Amendment to ensure accuracy of plans. (roof plan amended to match ground floor plan).

39 Willowhayne Avenue
East Preston
West Sussex
BN16 1PL

Roof Plan (1:100)

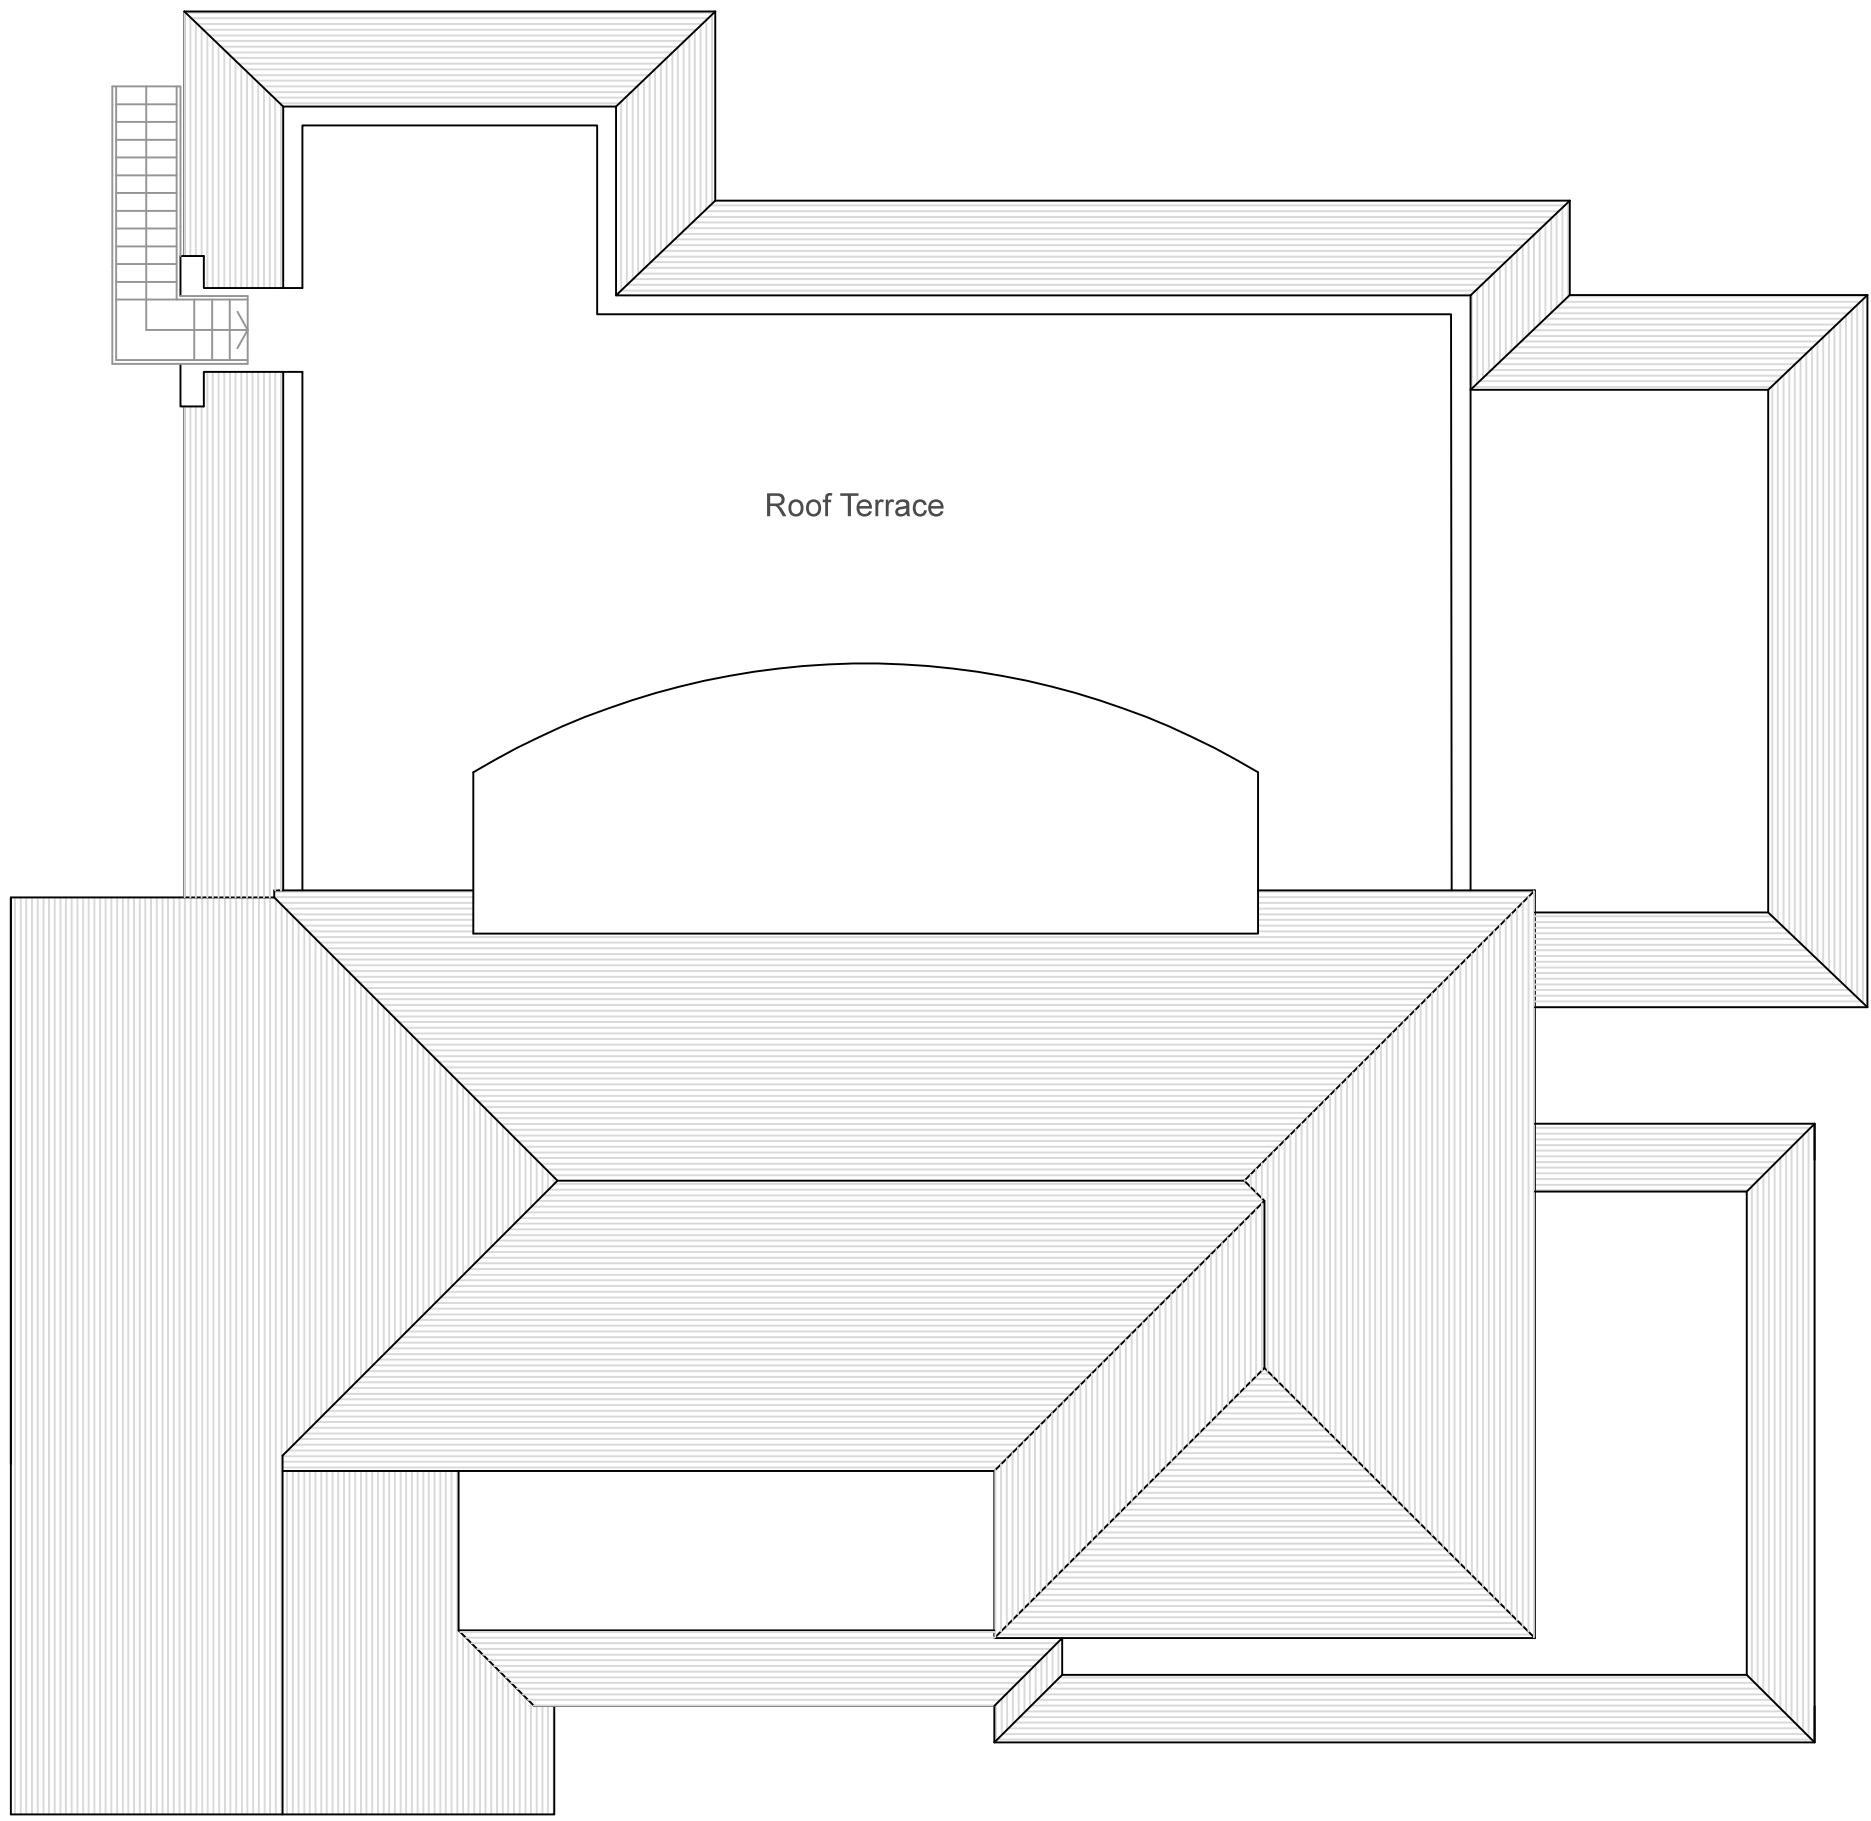
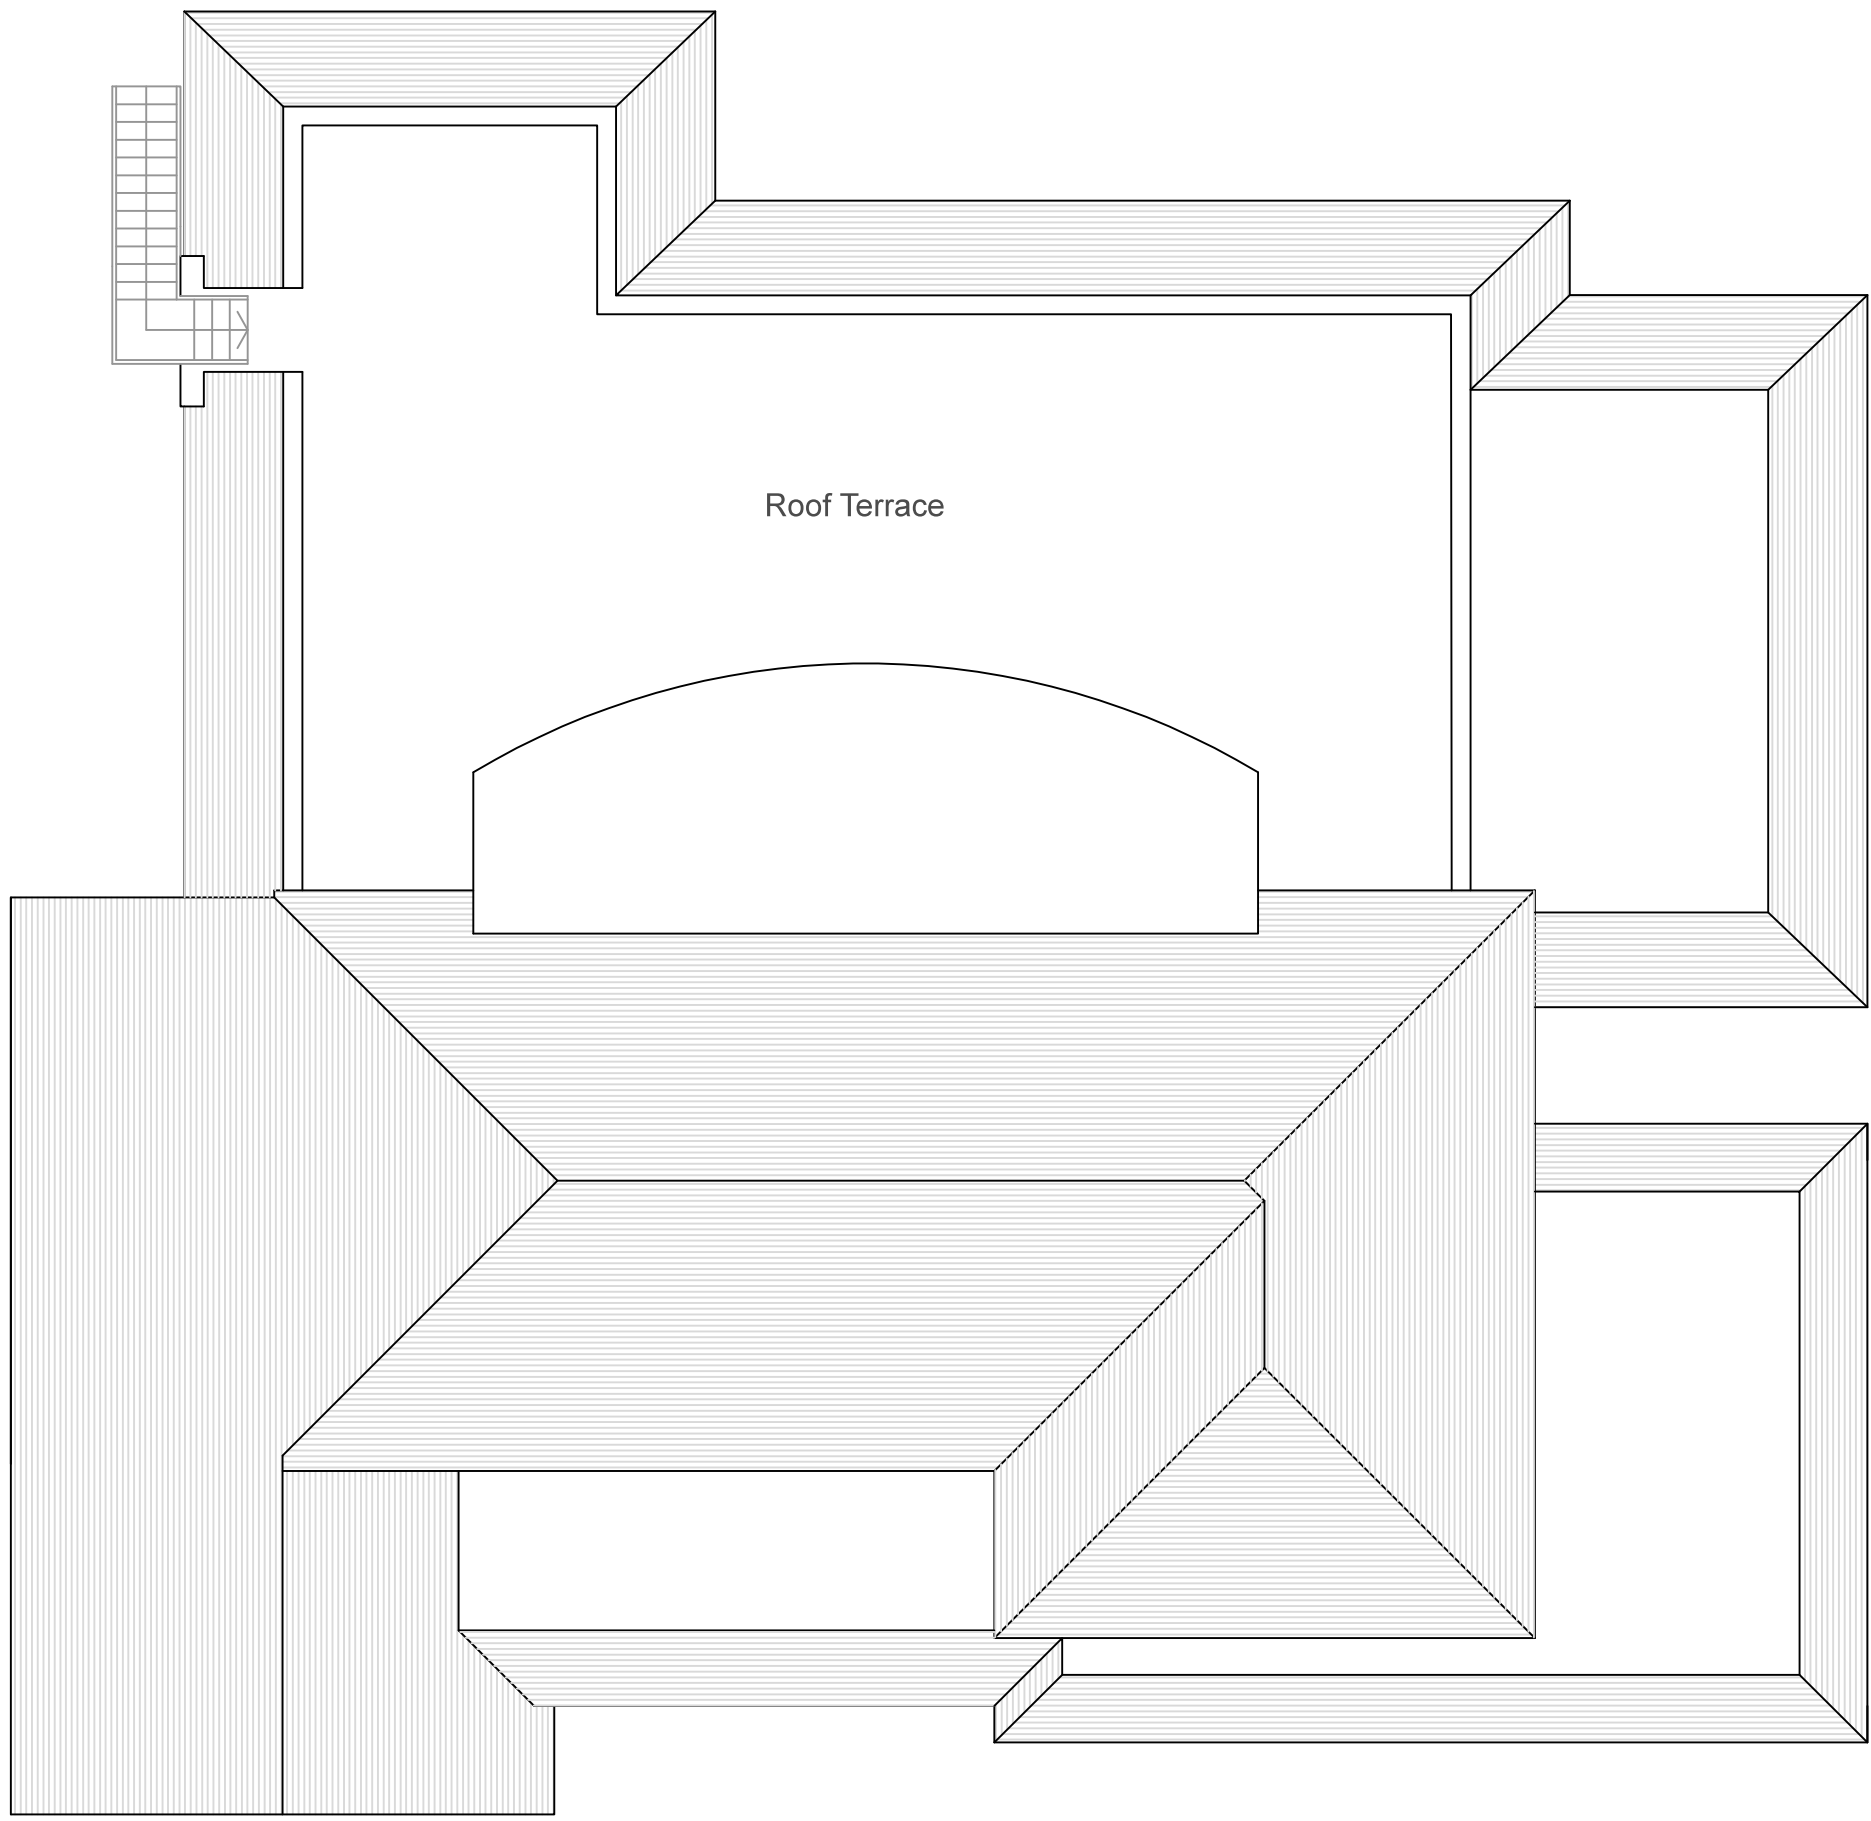
Further to our telephone conversation earlier today please find attached the proposed drawing with the roof plan amended.
